Rezoning Transportation Analysis

Petition Number: 2020-109

Date	Description
09-18-20	First Review
10-19-20	Second Review

EX01-REZONING PLAN

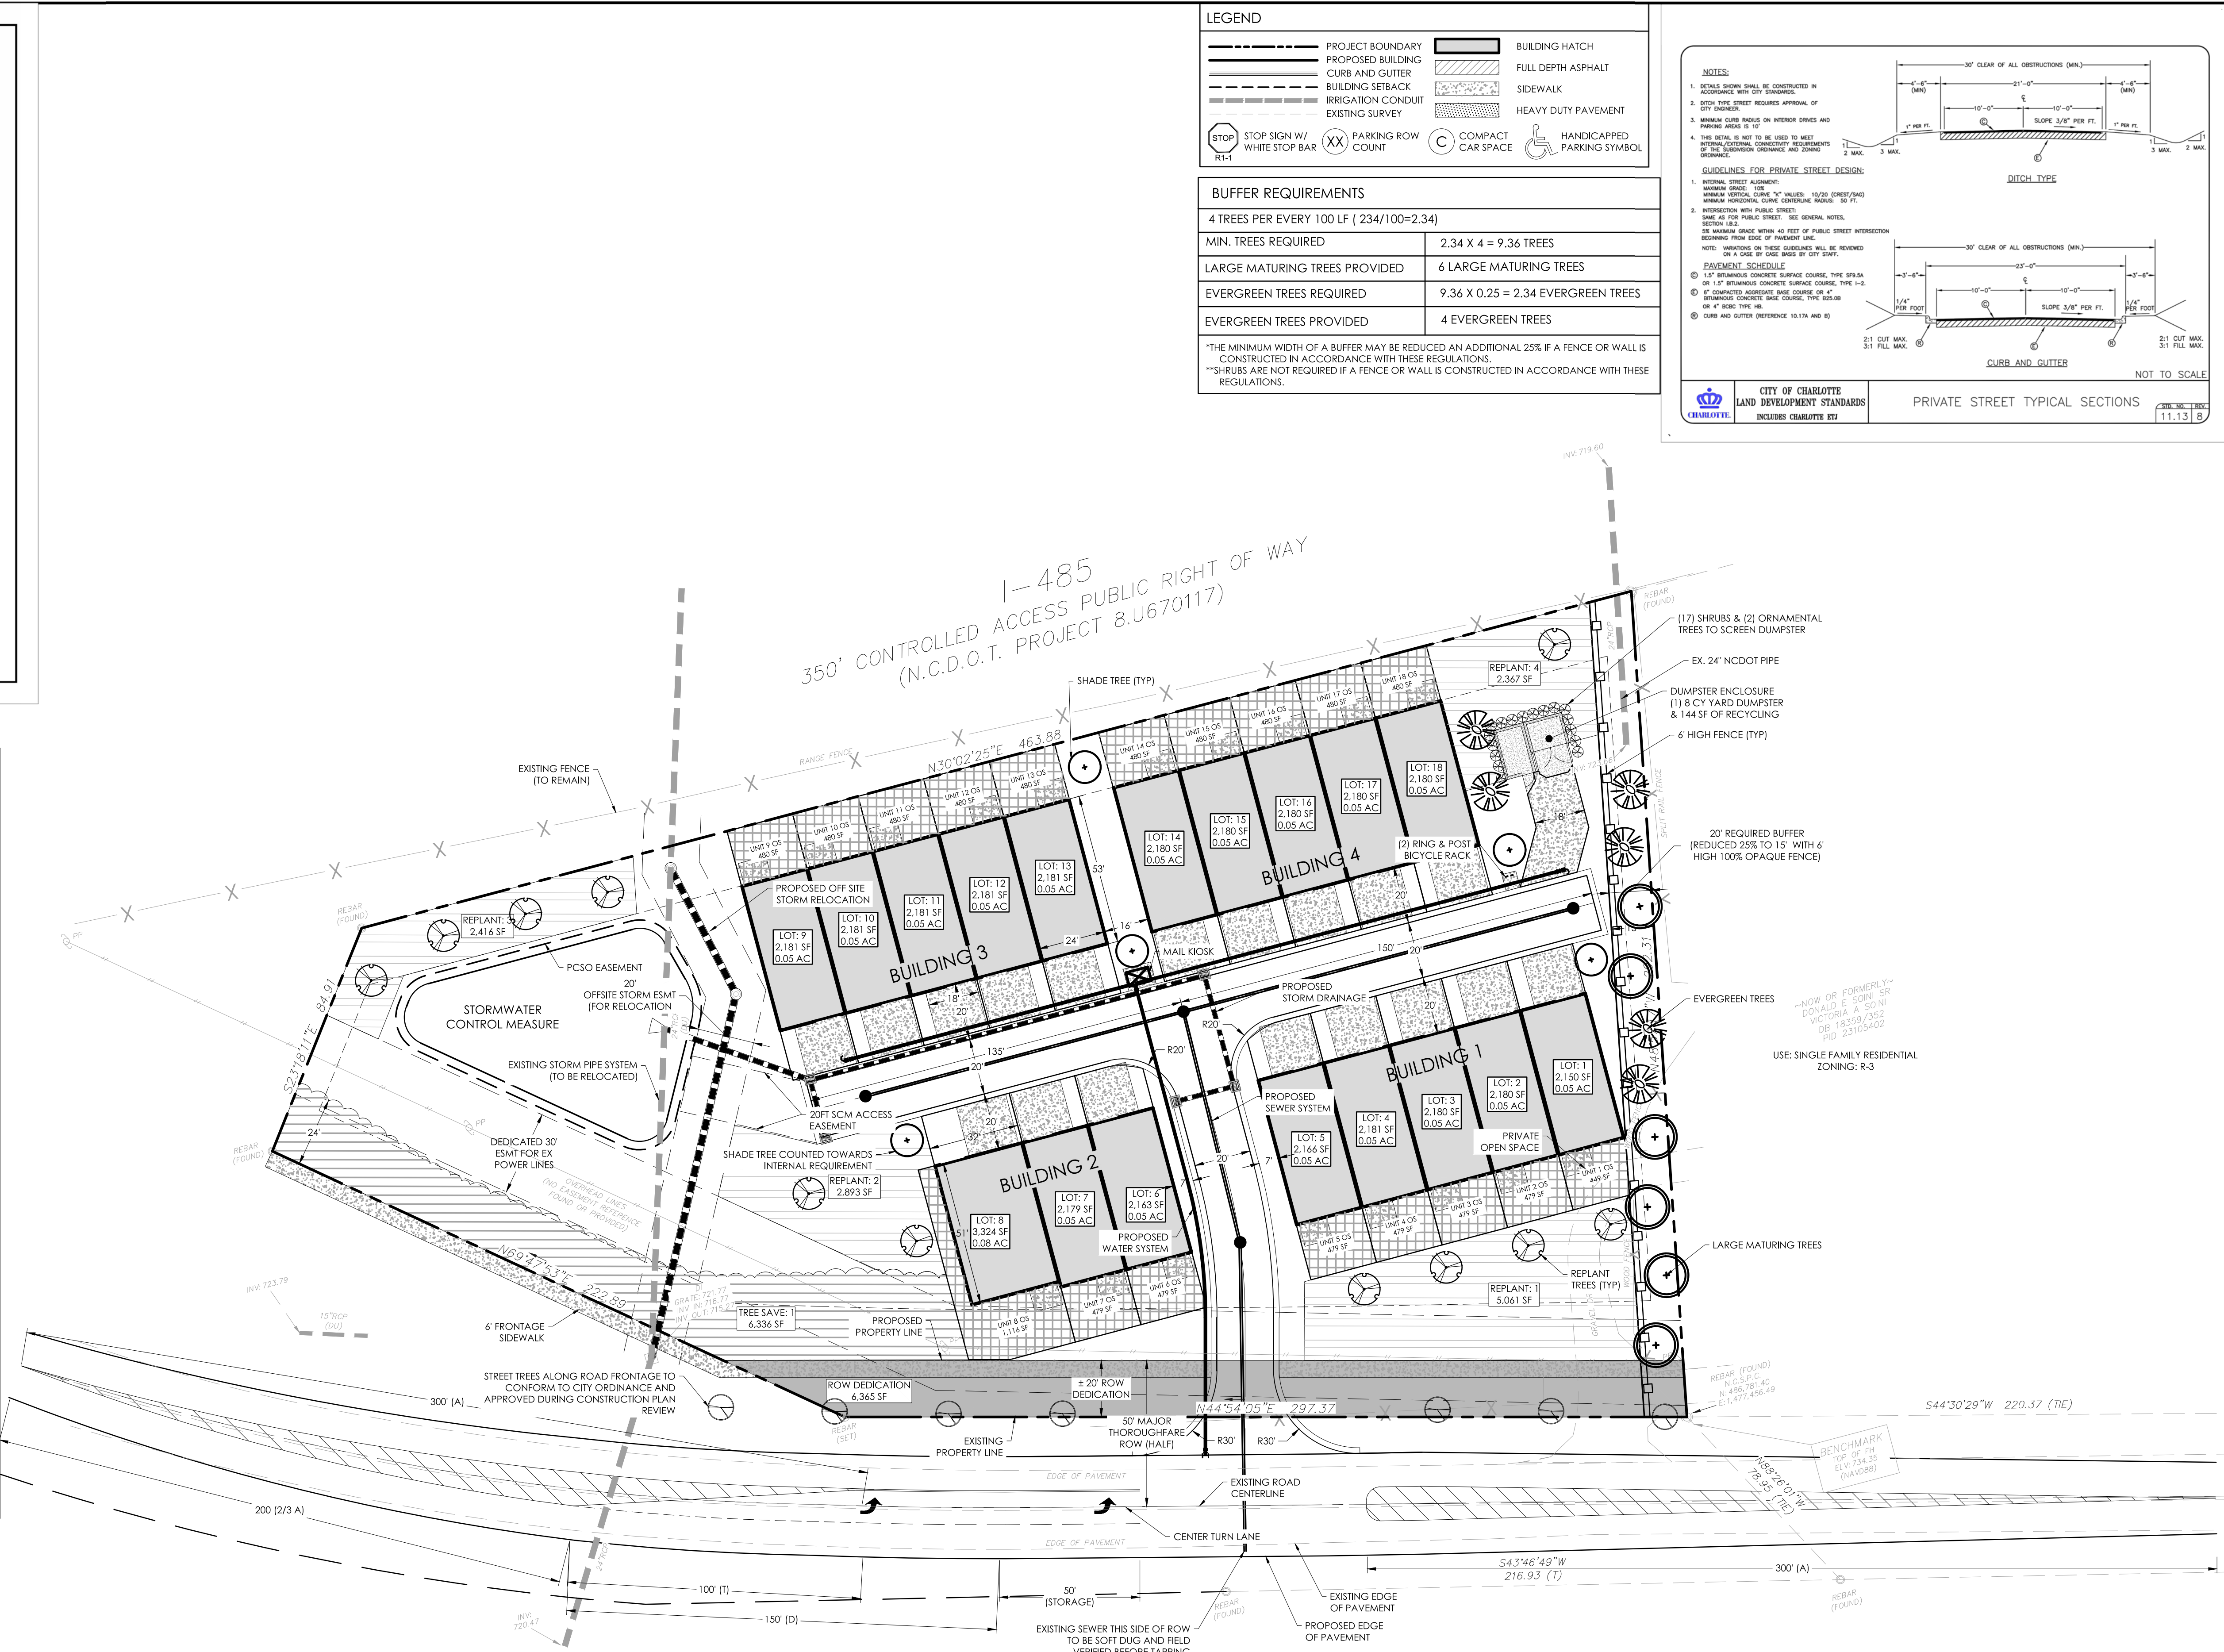
McKee Road (NCDOT): The future location of back of curb and gutter is 30' from the McKee Road centerline. The curb and gutter needs to be labeled and dimensioned from the road centerline to the back of curb on the site plan.

3. The site plan and conditional note(s) need to include an 8-foot planting strip on McKee Road per Chapter 20/Chapter 19. CDOT requests a 12-ft Multi Use Path in lieu of the required 6-foot sidewalk per the Charlotte BIKE Policy (primarily due to land use context and lack of frequent driveways). Both items need to be labeled and dimensioned from the back of curb and gutter and road centerline on the site plan.

4. Pedestrian sight triangles (NCDOT 10'x70') at the McKee Road driveway connection need to be reflected on the site plan. Label all roadways as private streets, where appropriate.
5. Provide ISD along McKee Road for driveway, both horizontal and vertical included to show standard meets NCDOT standards.
6. (Revised 10/19/20): Petitioner to relocate the inner crosswalk to alleviate the diagonal crosswalk at the 3-legged intersection.

7. (Revised 10/19/20): Petitioner to provide a 100' driveway stem from NCDOT ROW line, as per NCDOT standards.

8. ~~Add a note specifying all transportation improvements will be approved and constructed before the site's first building certificate of occupancy is issued. The petitioner may phase transportation improvements if said improvements and phasing are explicitly described in site plan notes.~~
9. A site plan note(s) specifying dedication and fee simple conveyance of all rights-of-way to the City before the site's first building certificate of occupancy is issued is needed. CDOT requests rights-of-way set at 2' behind back of sidewalk where feasible.
